CONSULTEE RESPONSE (Arun District Council - Arboriculturist)

Reference: CM/4/26/PL

Proposal: Subdivision of an existing dwelling to create two semi-detached dwellings, construction of a new access, two residential garages and associated infrastructure. This application is in CIL Zone 3 and may affect the setting of listed buildings.

Location: Rigates, Climping Street, Climping, BN17 5RQ

Project	Rigates, Climping Street, Littlehampton
Drawing	Tree Protection Plan
Date	12.02.26
Ref	25-2053-TPP
Drawn	NT
Checked	DR
Client	Savills
Scale	1:500@A2

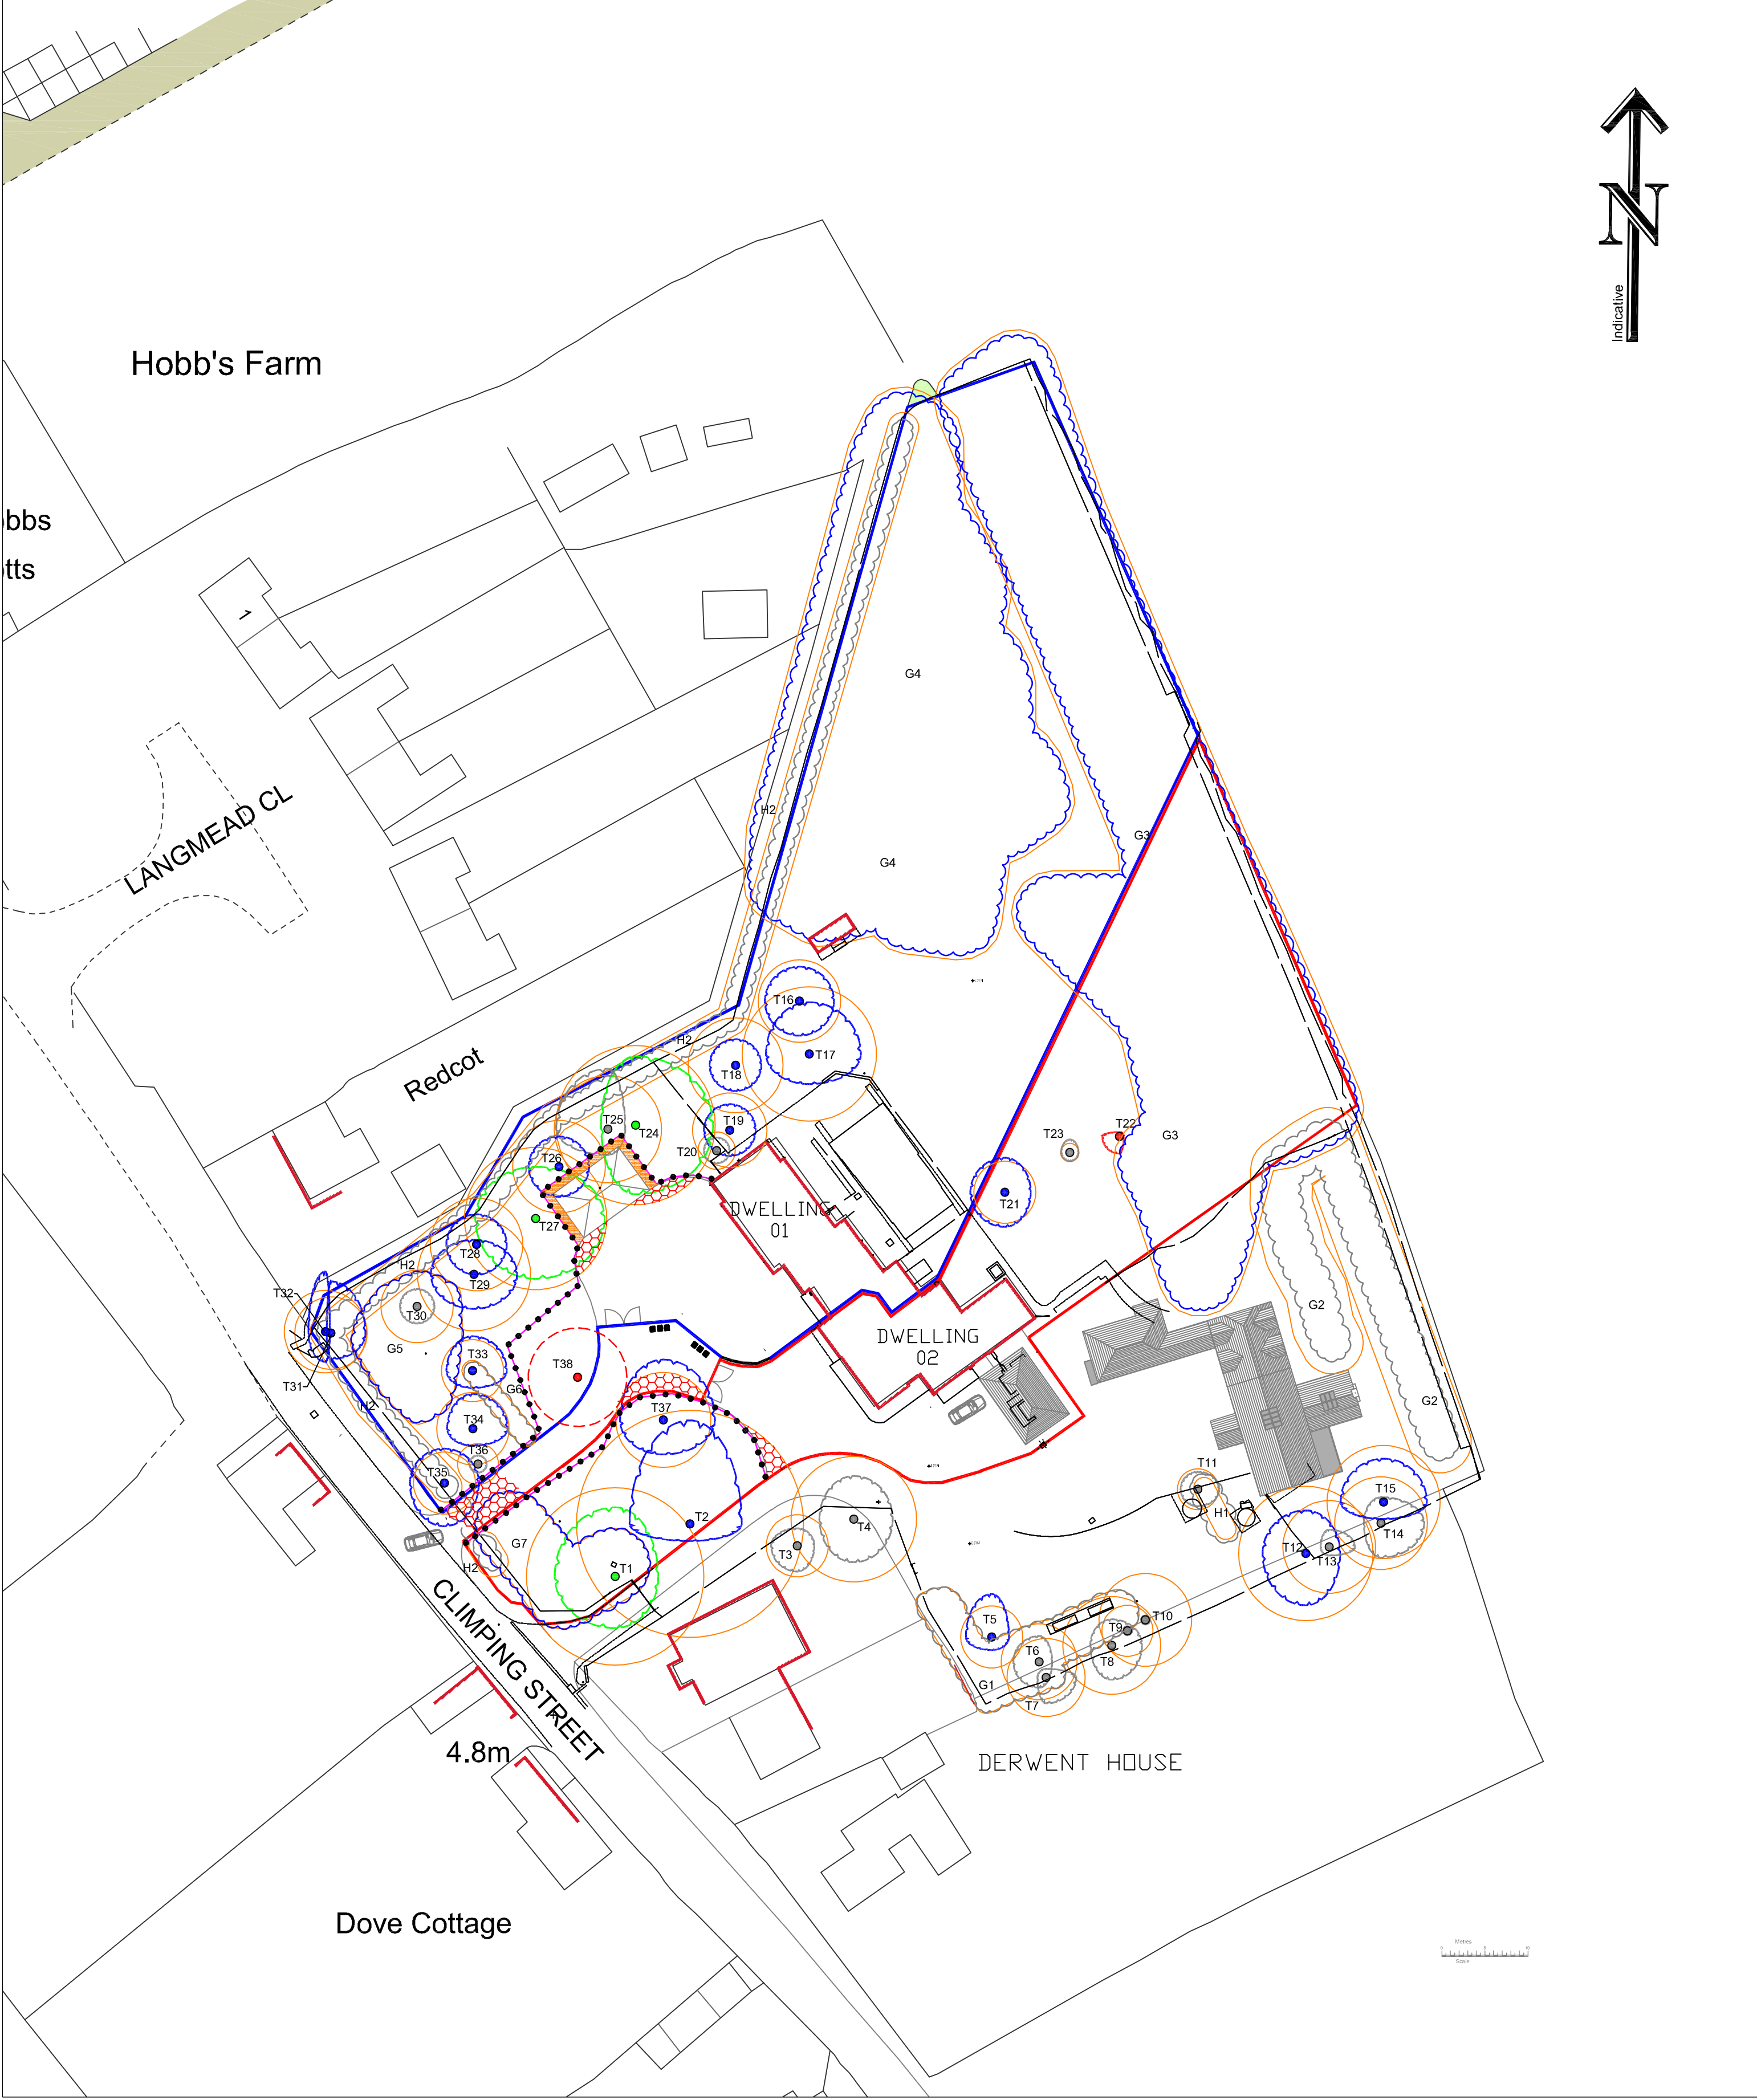
The main conflict is where a new detached garage block is sited, serving dwelling 01. This affects two of three category A trees on the site. The use of screw piles to support a raised floor, adopting a precautionary investigation with hand tools prior to their siting, is the least invasive method available, but nonetheless could impact greatly on those trees, given proximity, and extent of incursion. It should be anticipated that large structurally important roots will be encountered at this range, with unavoidable harmful impact incurred.

Furthermore, ongoing nuisance and a high risk of damage from falling debris would be understandably intolerable and might invite applications for substantial tree work or even removal.

The proposed location of the garage may be optimal from a design (aesthetic) perspective, while I suggest rotating clockwise 90deg. and to alongside the dwelling's northwest flank would maintain existing growing conditions for and unobstructed future growth of T27 cedar.

In the short term this amendment to the scheme would attract a higher arboricultural impact, due to the necessity for removal of T19, T20 & T24, although ultimately increase the amenity offer. This would have implications for biodiversity (BNG) calculation.

Compensatory planting of several standard trees, to include one ultimately comparable large specimen as replacement for T38 (category U = unsuitable for retention, scheduled for removal), would be a necessary mitigation for such a loss of canopy. This central location to the front of the property would seem ideal for both residents and public amenity.

The general 'principle of development' as described is achievable without undue detriment to retained trees, but it requires a more sympathetic and less intrusive layout to better preserve one of high amenity value. The current arboricultural impact is potentially high given the risks associated with the scheme. I suggest the applicant be encouraged to relocate the garage for dwelling 01, as I have described.

As it stands, I am unable to lend this scheme my support and so register an OBJECTION, although expect this to be easily overcome if there is willingness to revise layout and agree to suitable replacement tree planting, in accordance with my suggestions.
